## CCES RESPONSES

025/El Paso County

RE: Urban Landing PUDSP

I am in receipt of a referral request for Urban Landing located on Spanish Bit Dr and Struthers Road. in the Gleneagle community. The property is bounded on the west by Stuthers Road and Interstate 25 (Cat F-W, MP 157.40), in the Gleneagle community, El Paso County, State of Colorado. The developer proposes to build a development of 49 single-family lots on 6.57 acres. The site is proposing two full-movement access points onto local road Spanish Bit Drive. The property has the tax schedule No. 7136001045, currently owned by Elite Properties of America Inc. After review of submittals, we have the following comments:

URBAN LANDING PUD DEV. PLAN & PRELIMINARY PLAN		
	PRELIMINARY GRADING AND UTILITY PLAN		
DESIGNED BY	MAW	SCALE	DATE 4/01/2024
DRAWN BY	MAW	(H) 1" = 40'	SHEET 6 OF 9
CHECKED BY	(V) 1" = N/A	JOB NO.	1308.01

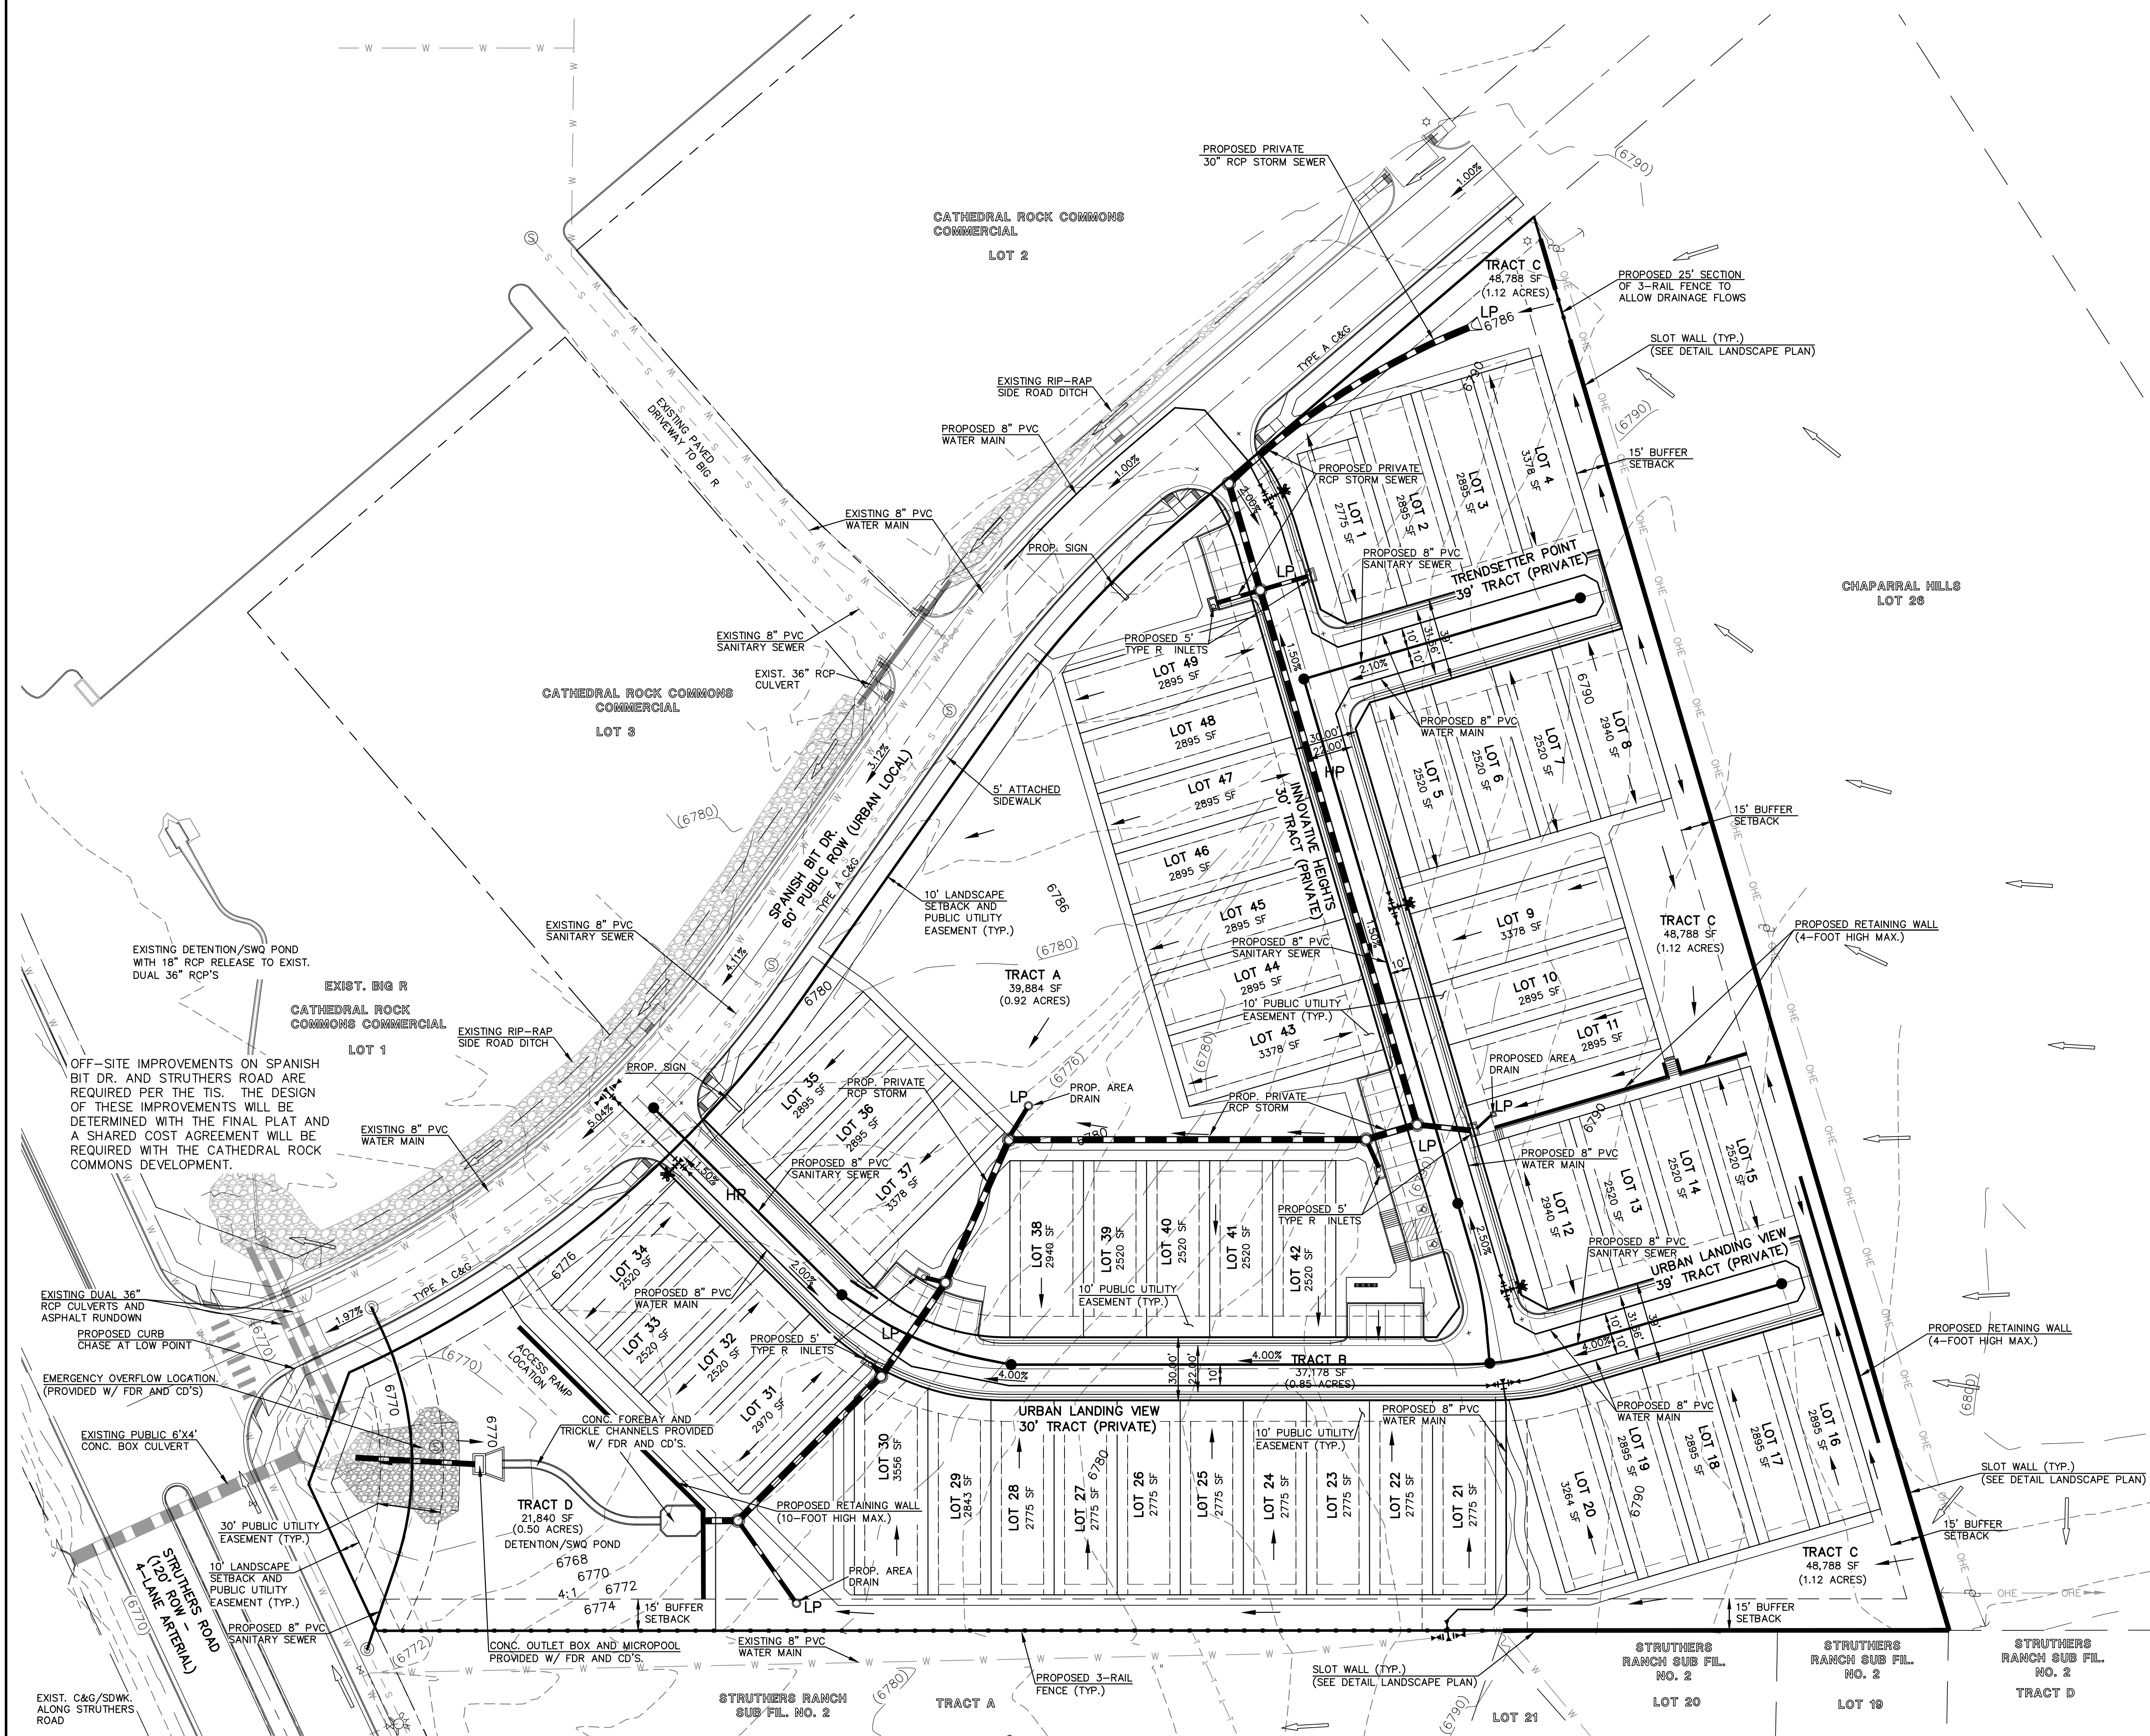
- Plan Comment:
  - As the design progresses, include detailed design plans of the pond. **Noted, we plan to provide detailed plans for the pond along with future Final Plat submittal.**
- Report Comments:
  - For the next submittal, include design point comparison for the flow into the existing culvert beneath Struthers. **This project will be providing a full spectrum detention facility on-site to be released at the existing Struthers crossing. Our future final drainage report will address and compare final design flows at this location.**
  - For the next submittal, include analyses of the Struthers culvert for existing/proposed/pond overtopping events. This will help to determine if there are any impacts to CDOT ROW from either outfall velocity or Struthers road overtopping. **See response above.**
